KITTITAS COUNTY
DEPARTMENT OF PUBLIC WORKS

MEMORANDUM

TO: Community Development Services
FROM: Kelly Bacon, Engineer Technician I *KB*
DATE: August 1, 2017
SUBJECT: Brownlee Short Plat SP-16-00004 – Conditions of Approval

BROWNLEE SHORT PLAT
PART OF SECTION 36, T. 17 N., R. 19 E., W.M.
KITITAS COUNTY, WASHINGTON

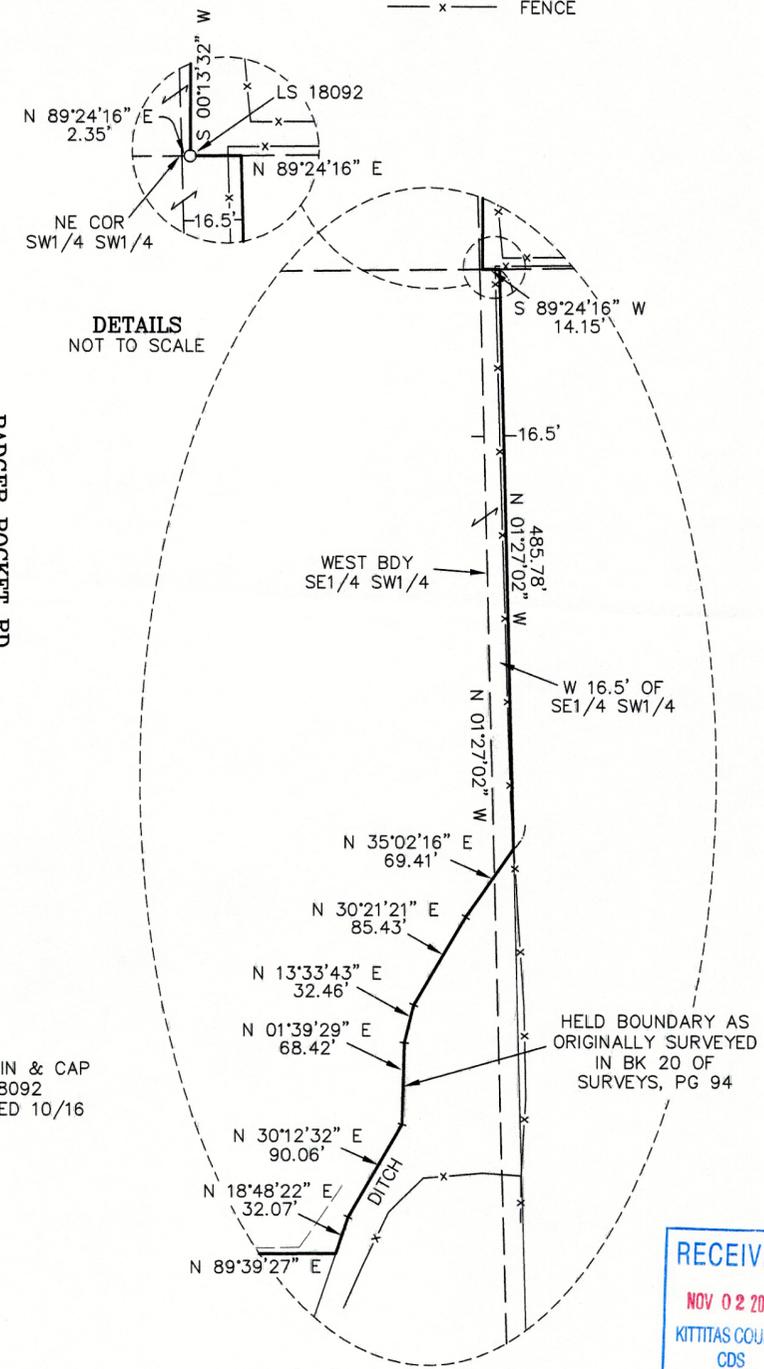
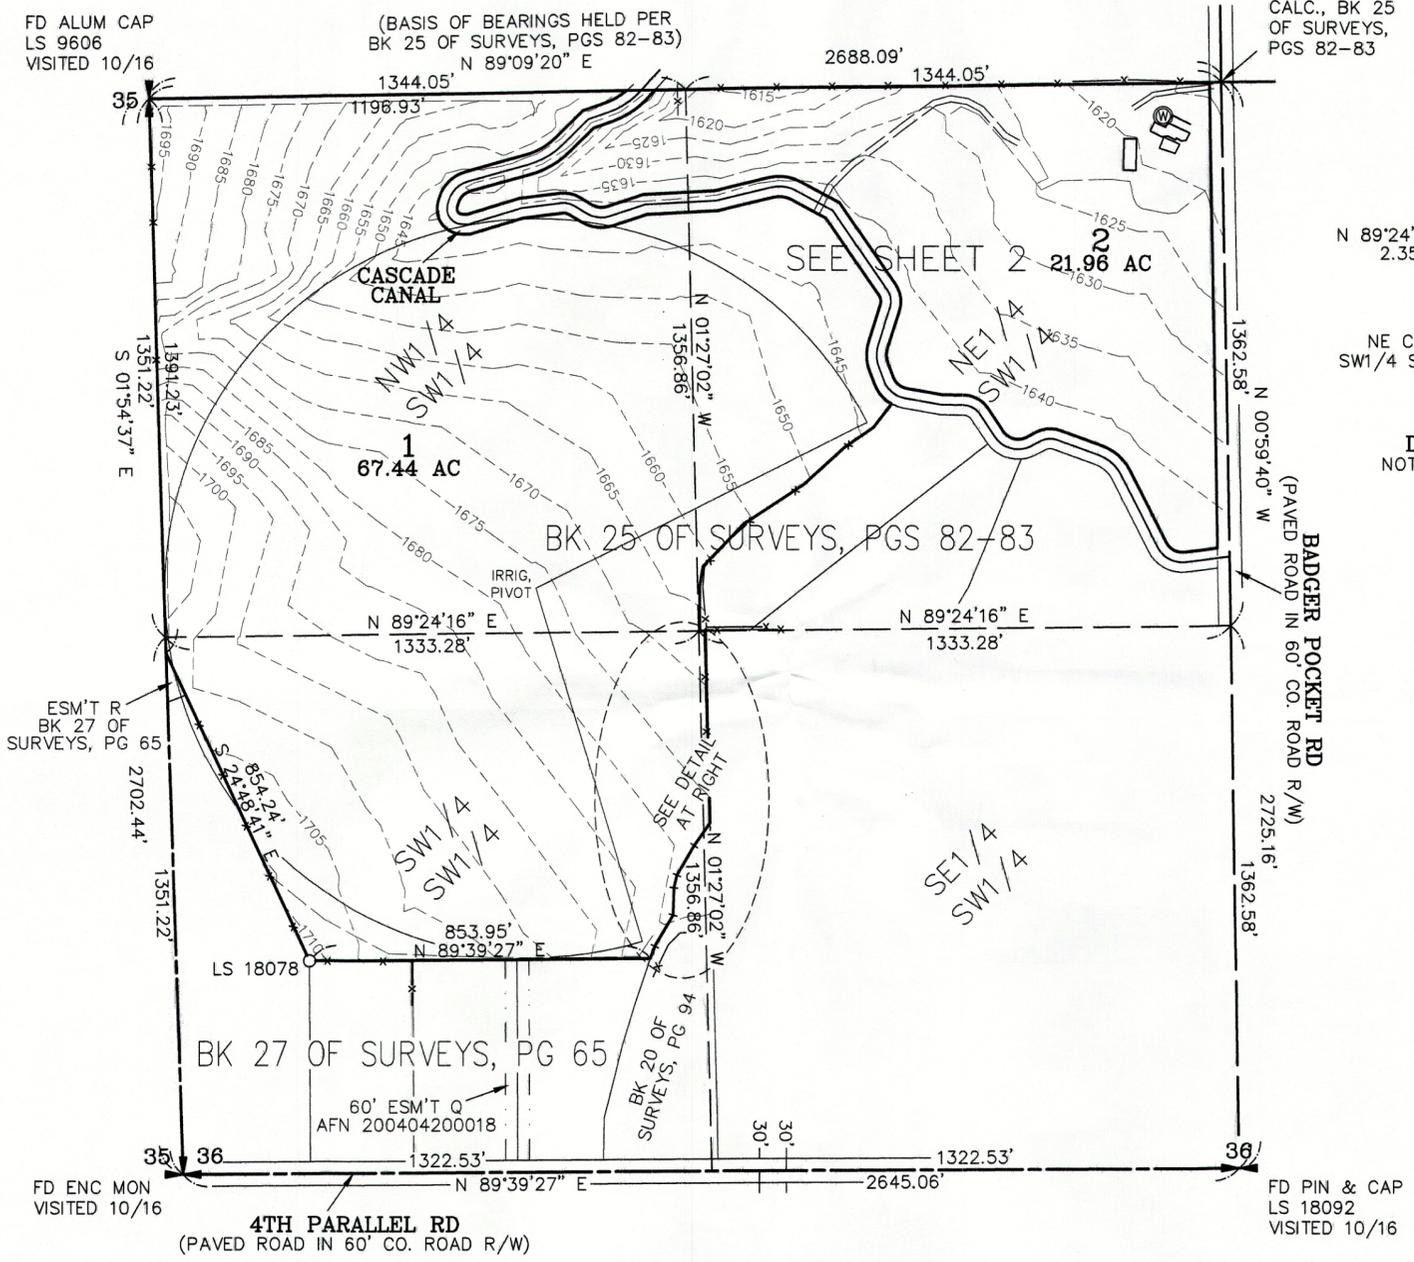
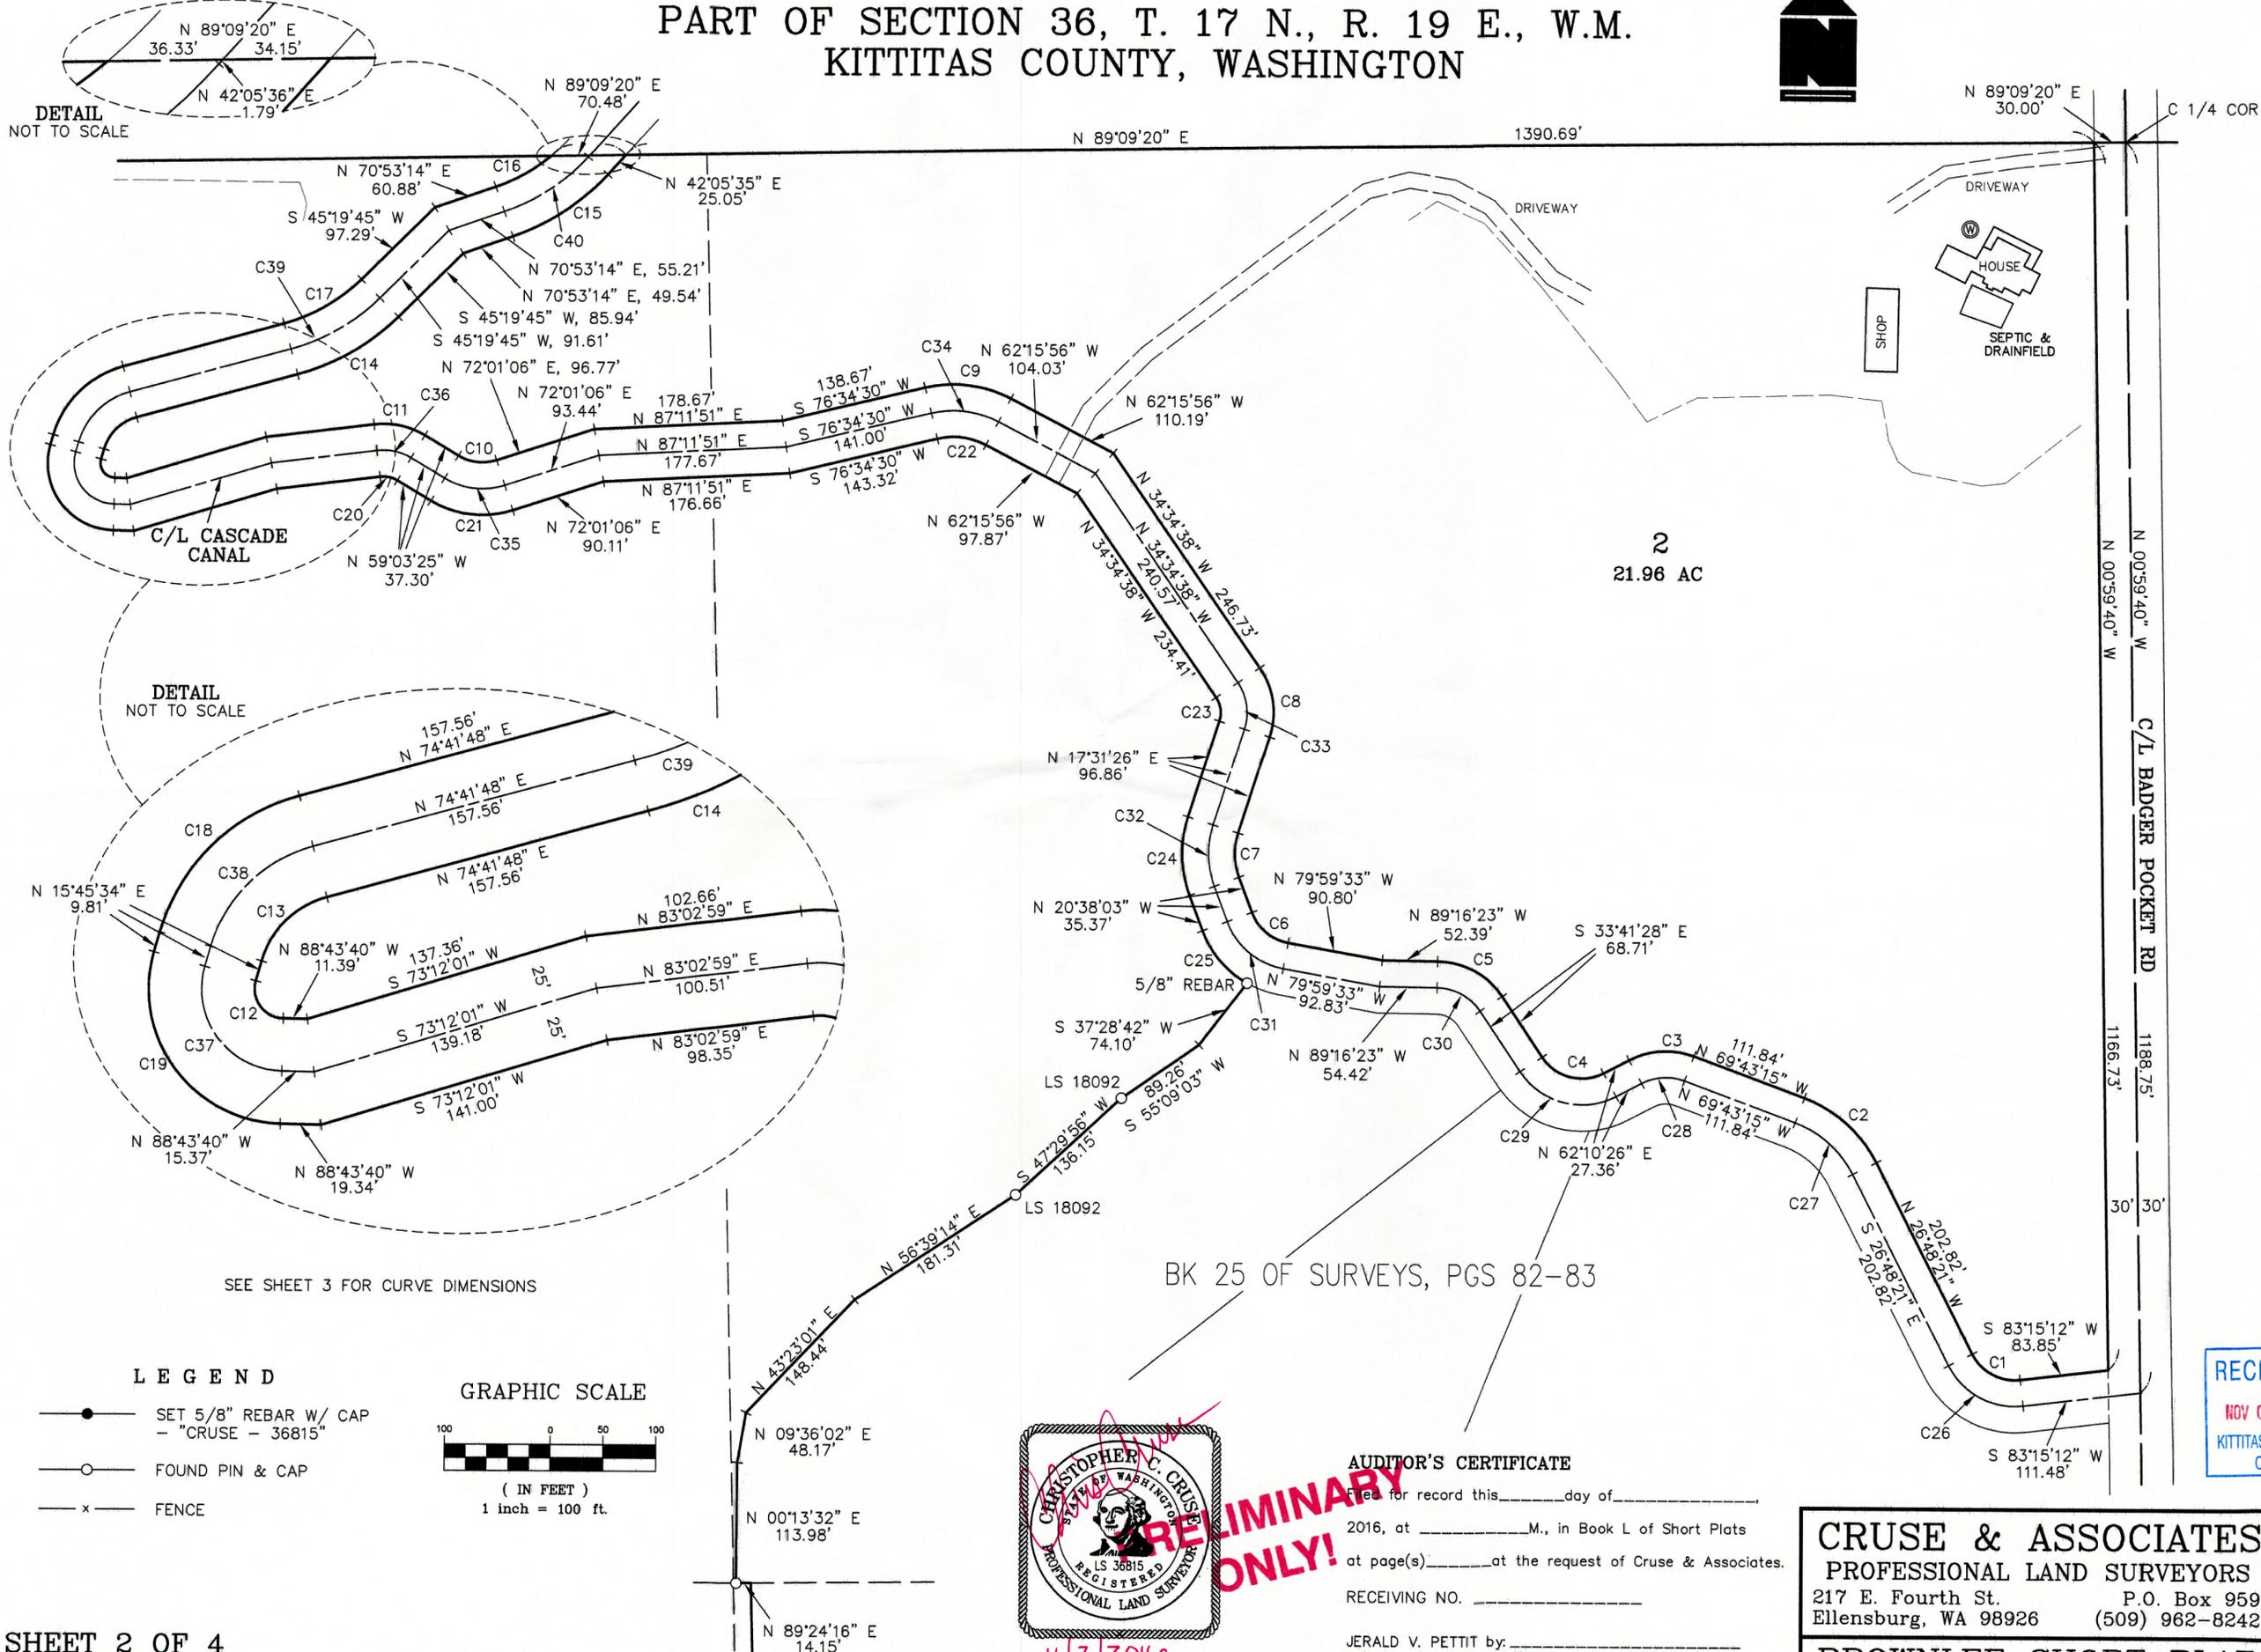
Lot 1: Short Plat note 18 states that Parcel 1 of this short plat has been placed in a conservation easement recorded under AFN 201707110005. Access easement Q is for agricultural use only. No residential access will be granted to this parcel of land
